Our Case Number: ABP-314724-22

Re: Railway (Metrolink - Estuary to Charlemont via Dublin Airport) Order [2022]
Metrolink. Estuary through Swords, Dublin Airport, Ballymun, Glasnevin and City Centre to
Charlemont, Co. Dublin

Metrolink Planning Permission

Station Canopy Design and Park Reinstatement

MATER STATION

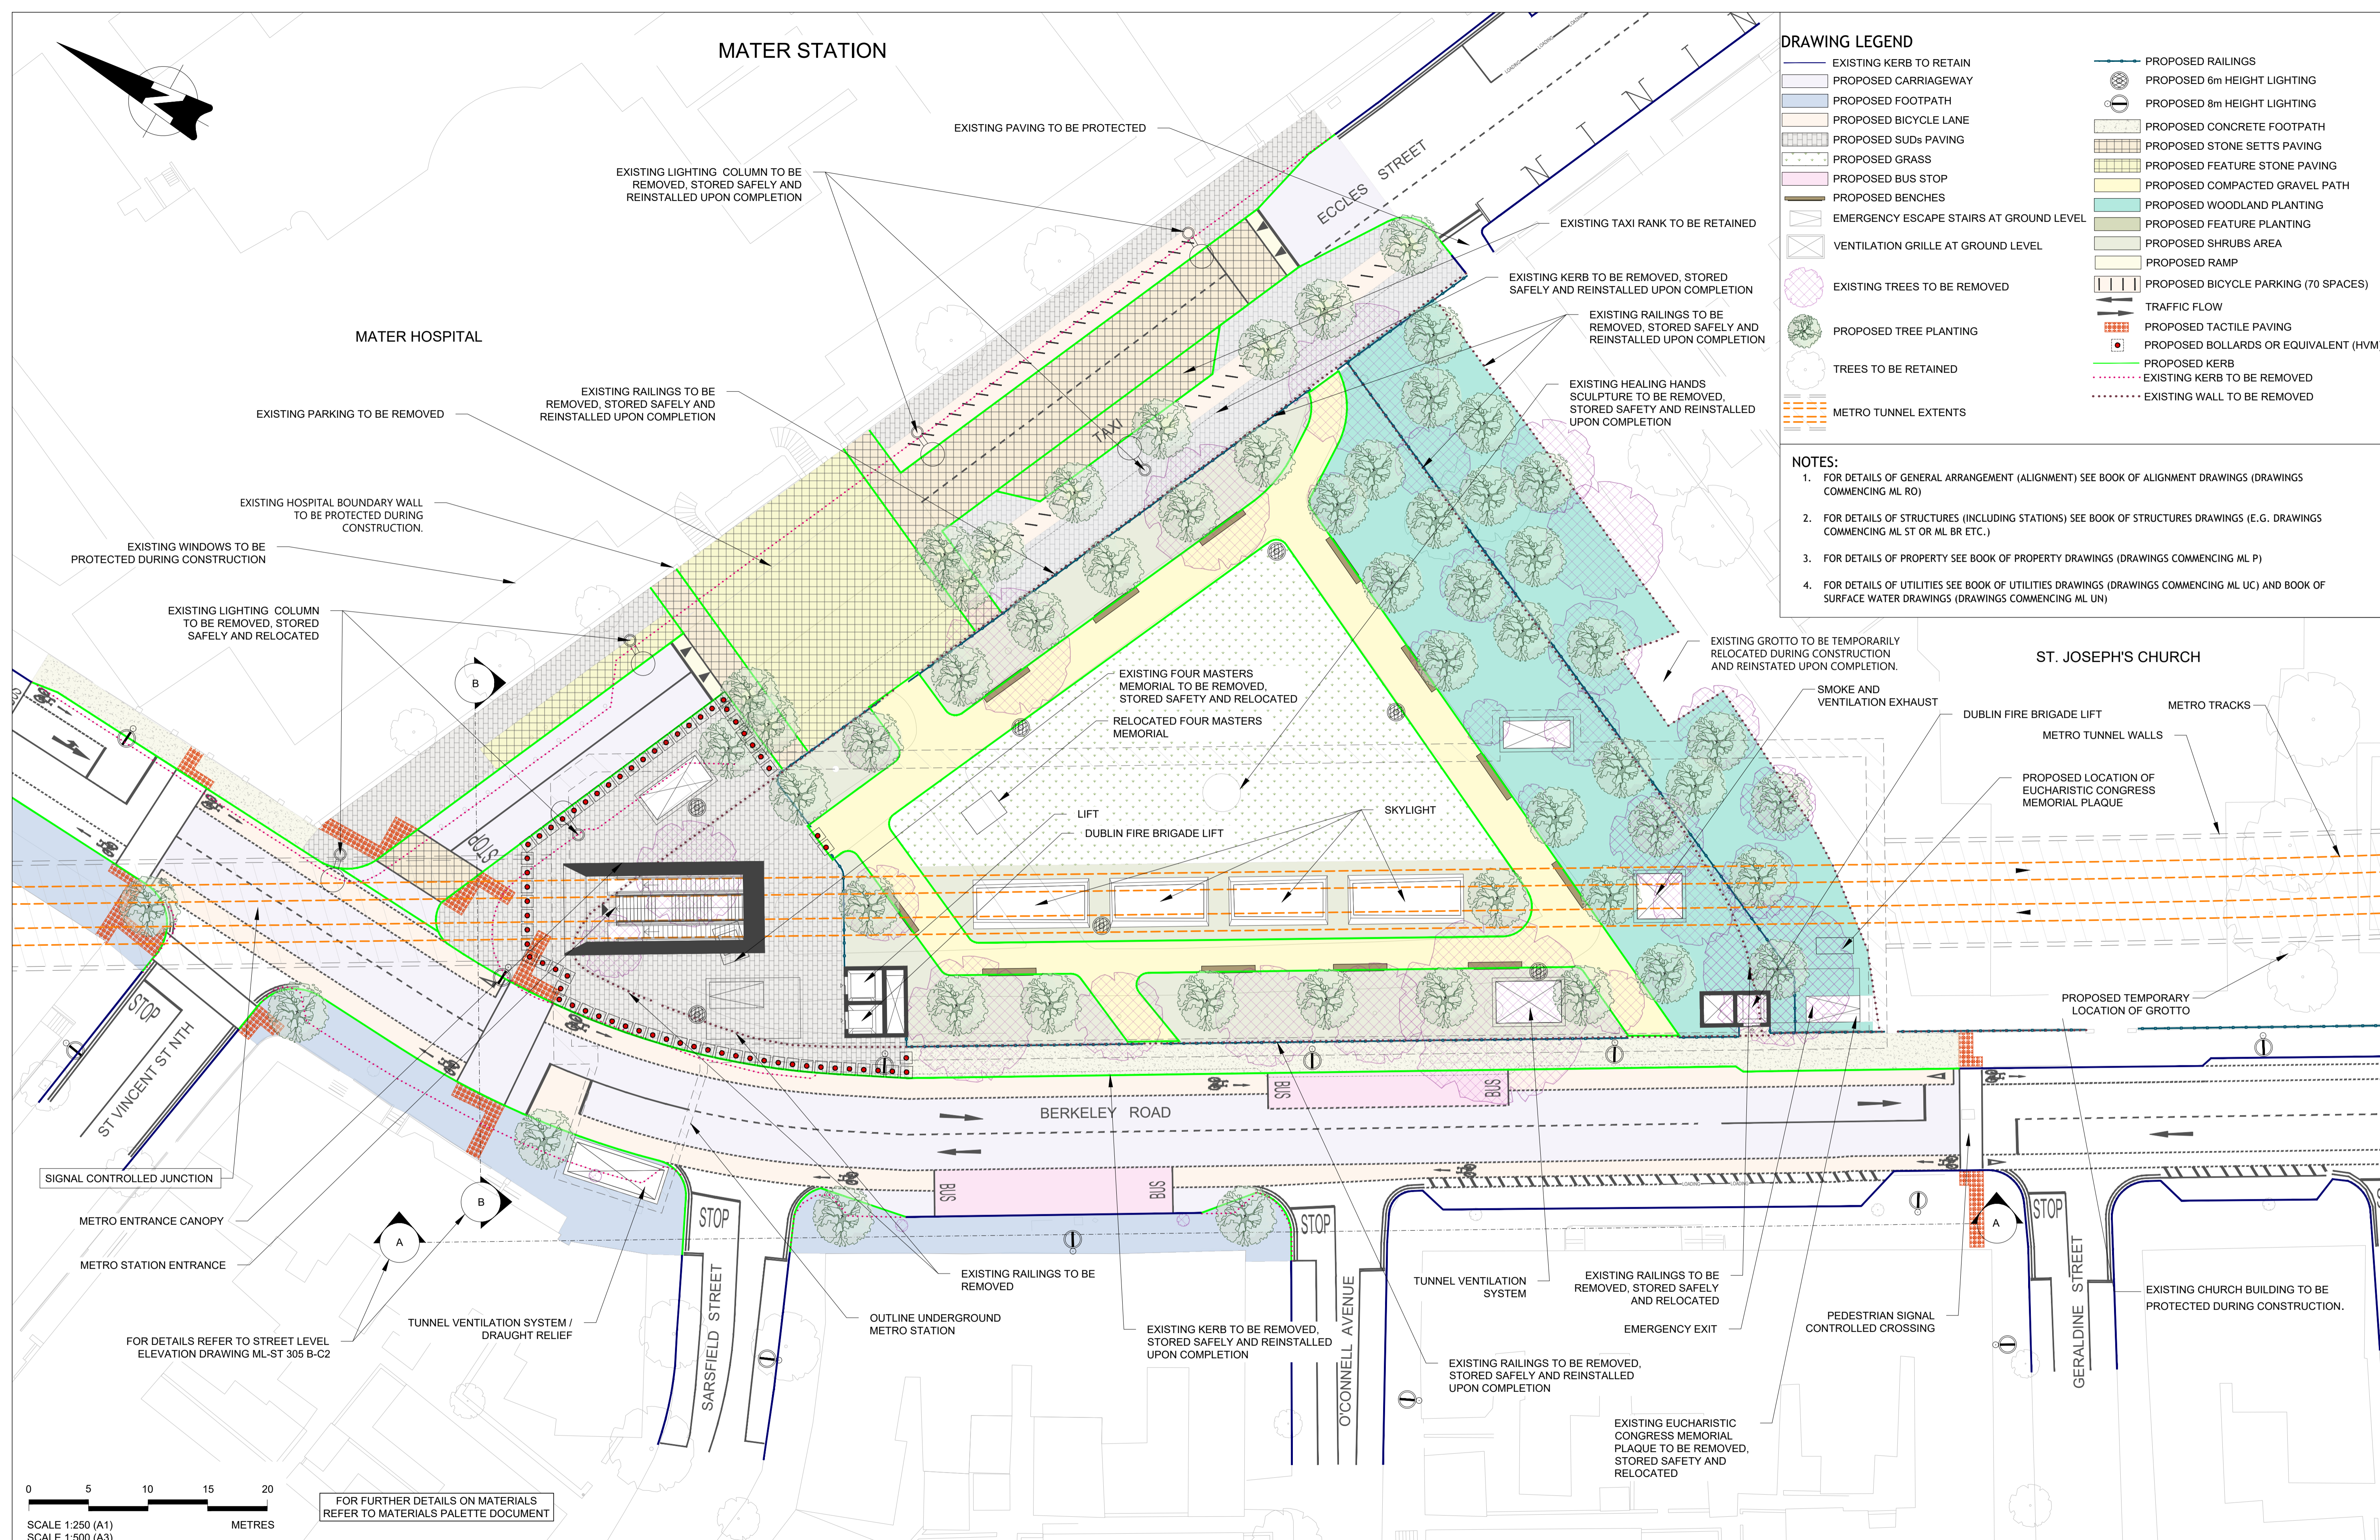
1) The combined effect of the heavy slate portico , the wedge shape and the height of the Mater Stop canopy building not only obscures the view of the Mater Hospital from Berkeley Road but is in itself visually overwhelming as it is located on a small site surrounded by roads and encircled by red brick houses and the imposing presence of the Mater Hospital behind it .

2) The inappropriate size and the poor visual quality of this canopy in this small location will increase anti social behaviour in an area that is already challenged by social and mental pressures that is associated with inner city living .

1) A new canopy design that is visually lighter in appearance and through which you can see the Mater Hospital Edifice such as the metro canopy at Gare St Lazare, Paris

The design and height of these lifts , obscure the visual impact of the Mater Hospital from Berkeley Road .

The functional design and the materials used in this building is inappropriate to this location and will dominate the visual impact of the park and the Mater Hospital building from Berkeley Road . It will visually impair the streetscape of Berkeley Road.

This area is unnecessarily large and would be visually more aesthetic with more planting . TII have done a similar design in Broadstone and

It is a mistake as the extent of paving is very dominant visually . The extent of paving is not sustainable as it will require frequent cleaning to remove chewing gum .

There is an excessive amount of bollards in this small area, what about trees as in Grafton St.

Given the proximity of Blessington Basin and the recent bat survey by DCC Parks, there should be provision made for Bat friendly lighting in the area around the Mater Stop Station and the Four Masters Park.
